Our Ref: FP/69/18/PL

**Town & Country Planning Act 1990 (as amended)
Town and Country Planning (Development Management Procedure) (England) Order 2015
Application for Planning Permission**

Development Retention of extraction unit with steel flue, external lighting, 2 No. air condition units & external decking.
Location The Felpham Club 43 Felpham Way Felpham

SITE LOCATION & BLOCK PLANS			
Scale	1:1250 - 1:500	Drawn By	ACB
Date	17/08/2015	Checked	CB
Drawing Number	1240 - 01

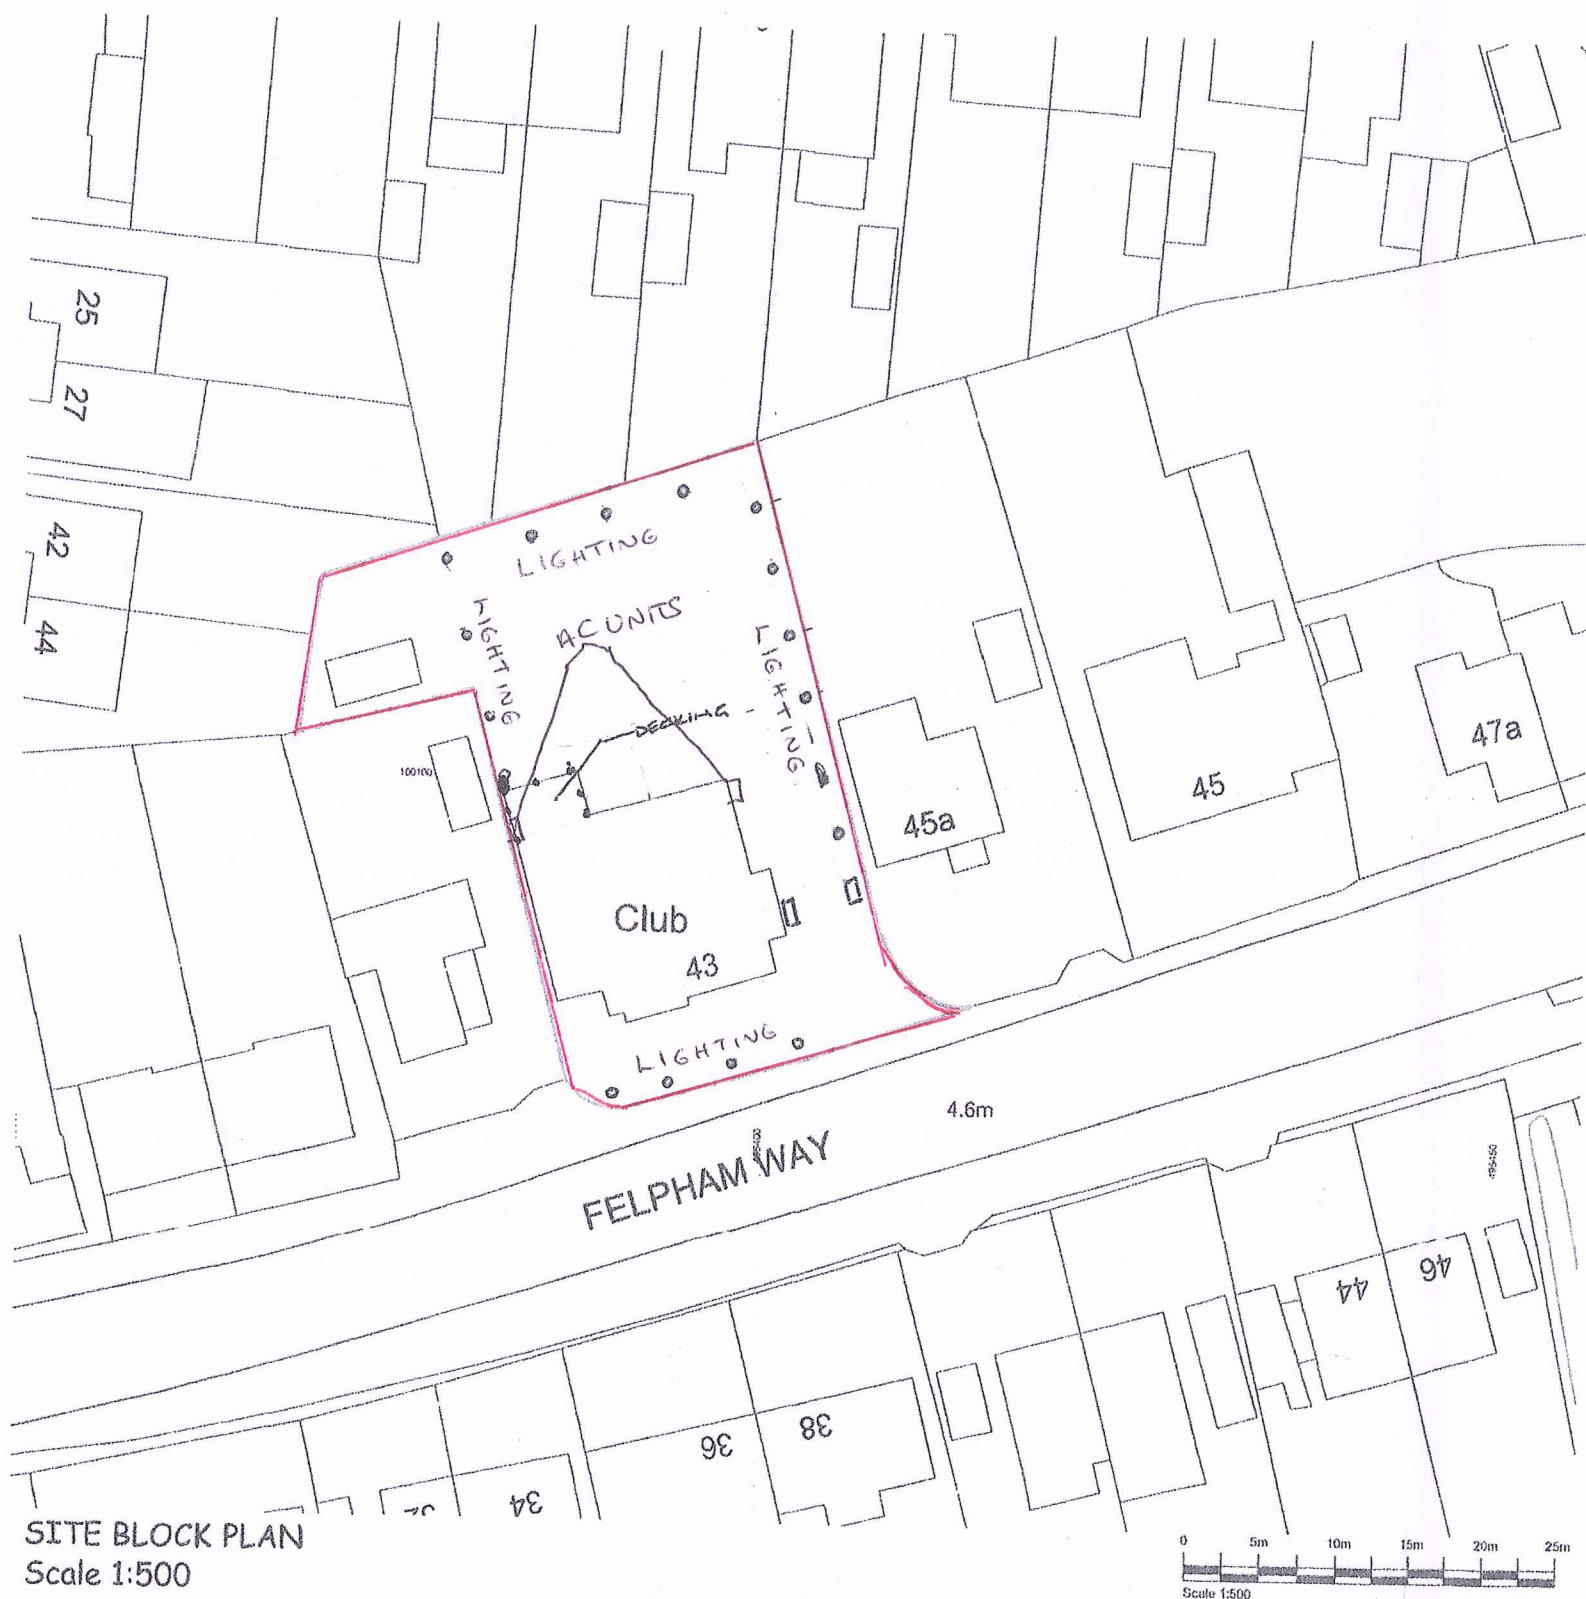
Location Plan Amend

Please submit 1 electronic or 3 paper copies of a location plan at a scale of 1:1250 or 1:2500 for rural areas. Further details of what must be included on the plan can be found in the National Validation Requirements. Please provide a red edge around the application site.

Block Plan Amend

Please submit 1 electronic or 3 paper copies of a block/site plan at a scale of 1:500 or 1:200. Further details of what must be included on the plan can be found in the National Validation Requirements. Please clearly highlight all proposed works.
